OFFICIAL NOTICE OF DECISION

CITY OF ALBUQUERQUE
PLANNING DEPARTMENT
DEVELOPMENT REVIEW BOARD

Project# 1010144

15DRB-70303 - PRELIMINARY PLAT

PLAT OF
TRACTS 3-A-1 AND 4-A-1
SANTA MONICA PLACE

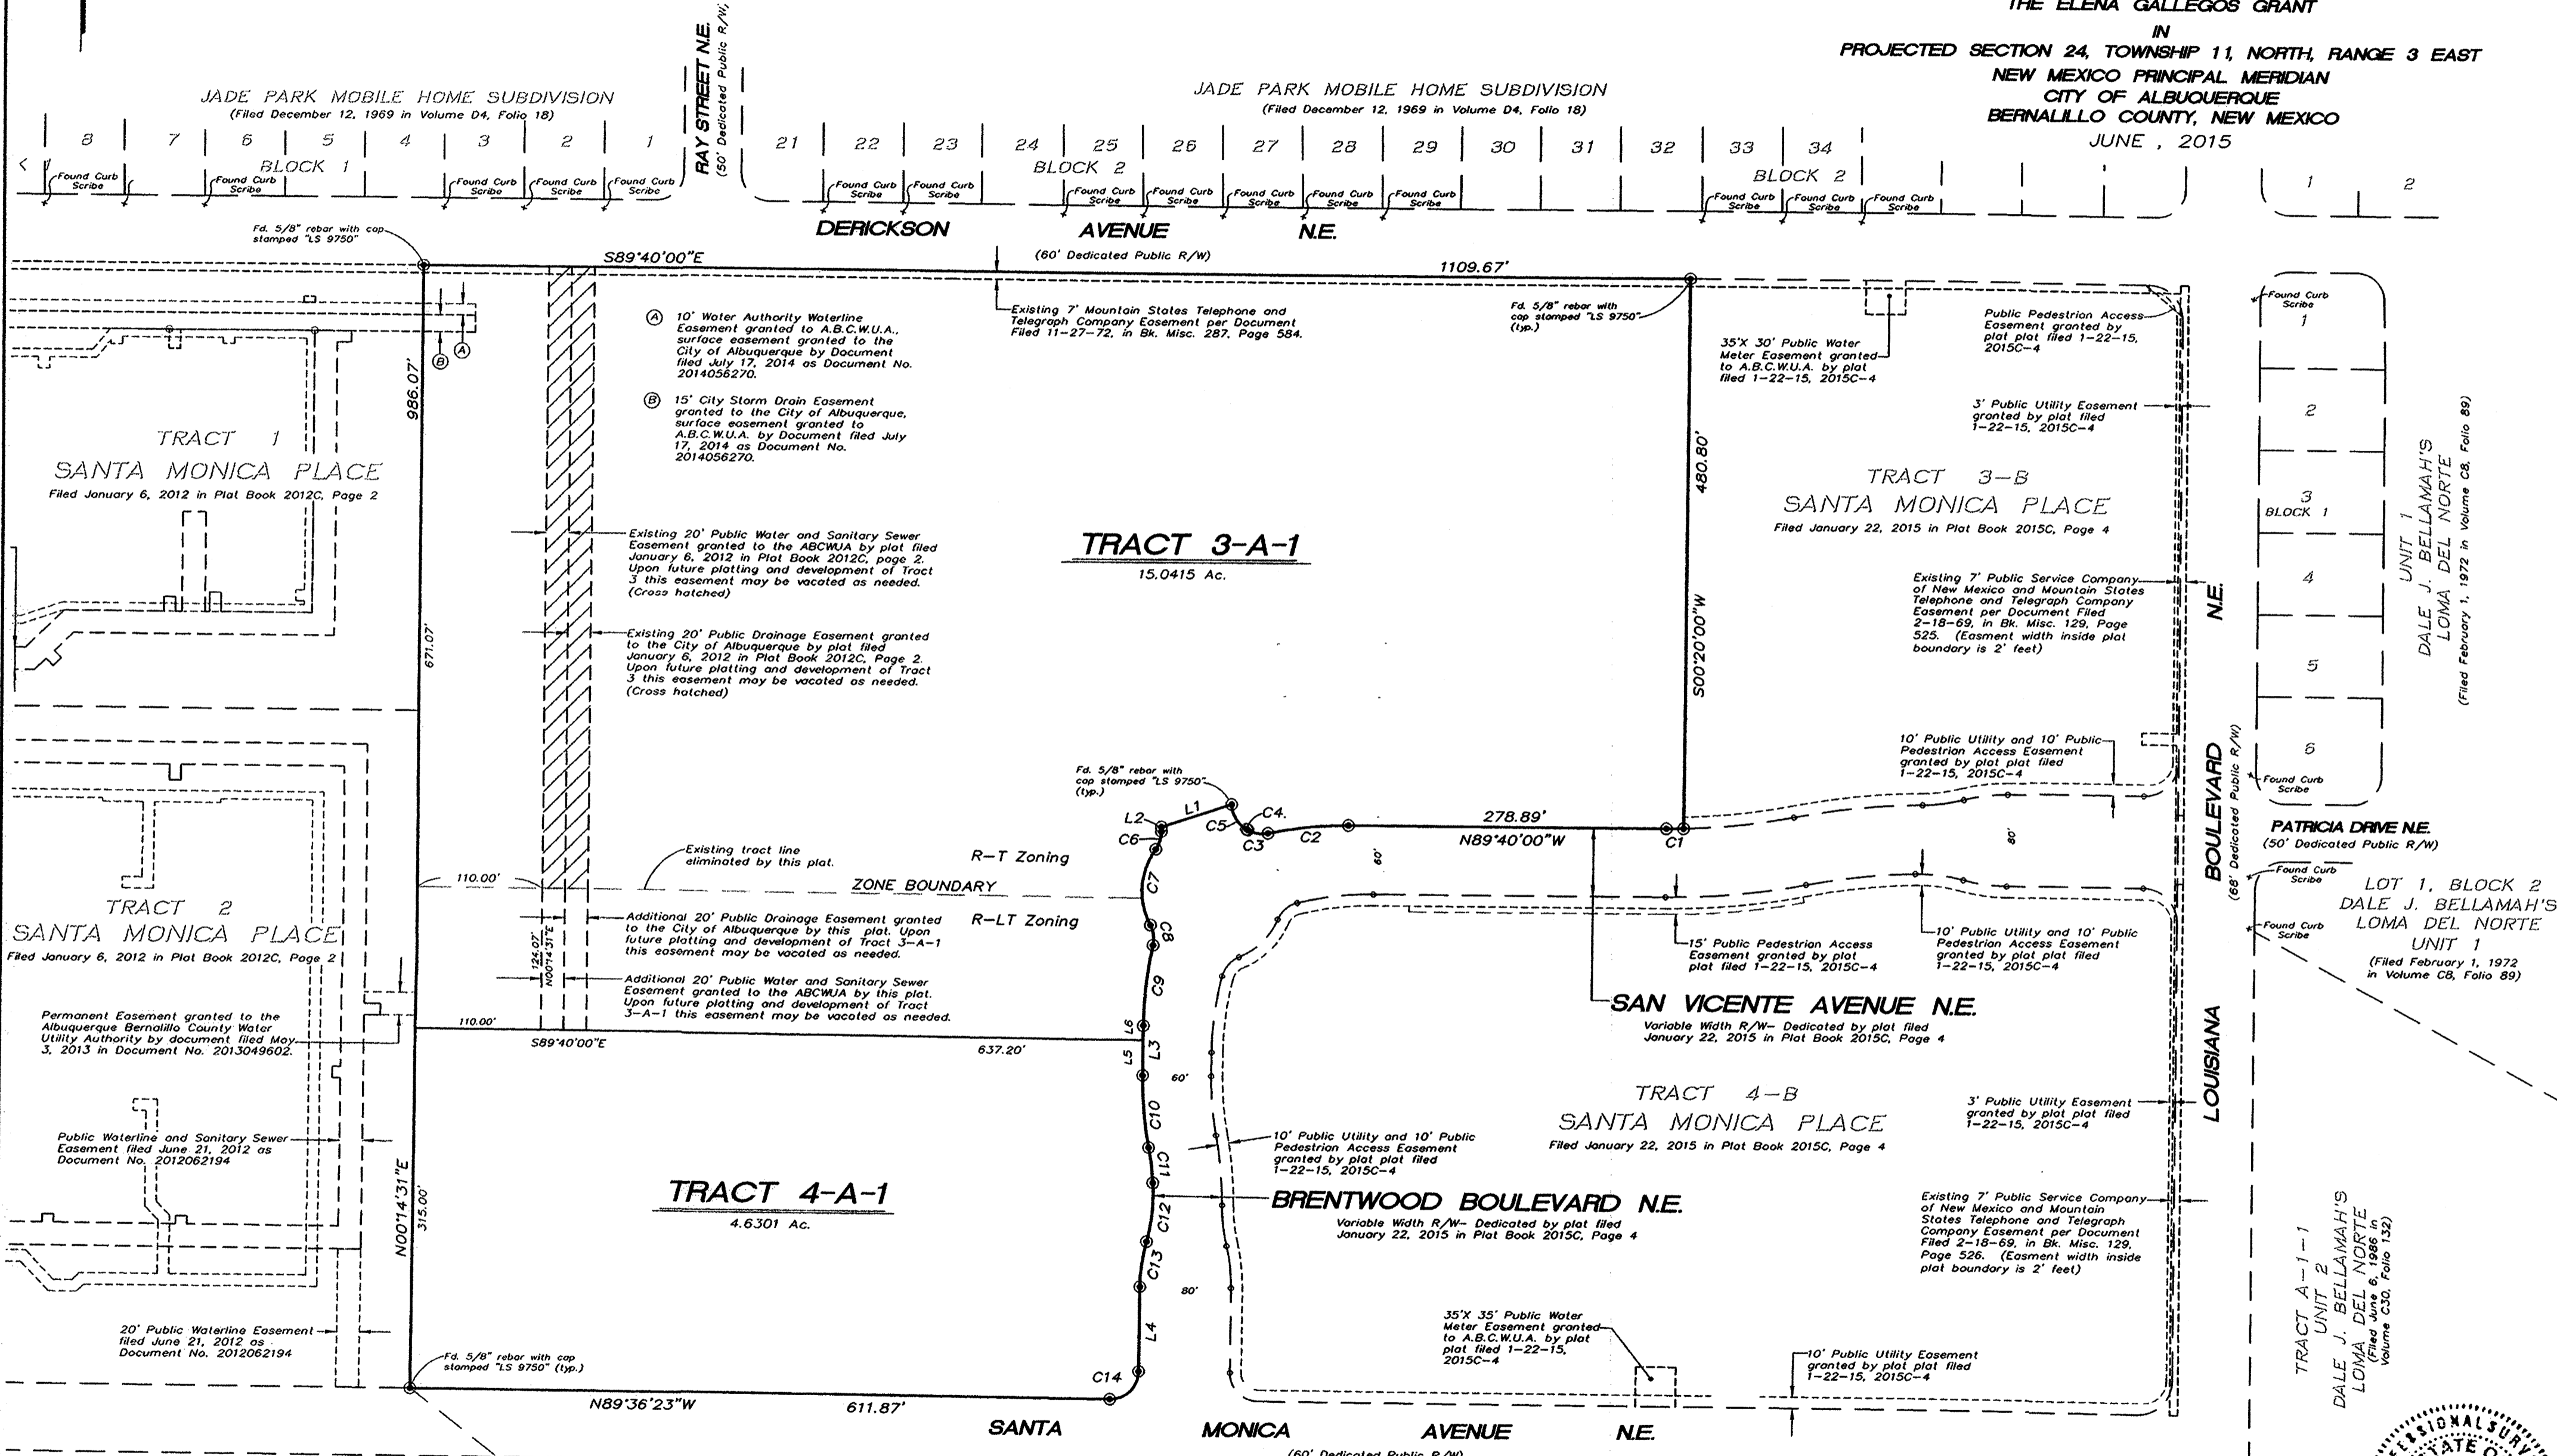
Planning: AMAROK signature, show Zone Boundary "OK" "OK"

The existing lot line is the Zone Boundary between the R-T Zone/
Tract 3-A and the R-LT Zone/ Tract 4-A; a Zone Map Amendment/
zone change from R-LT to R-T should be requested prior to platting.
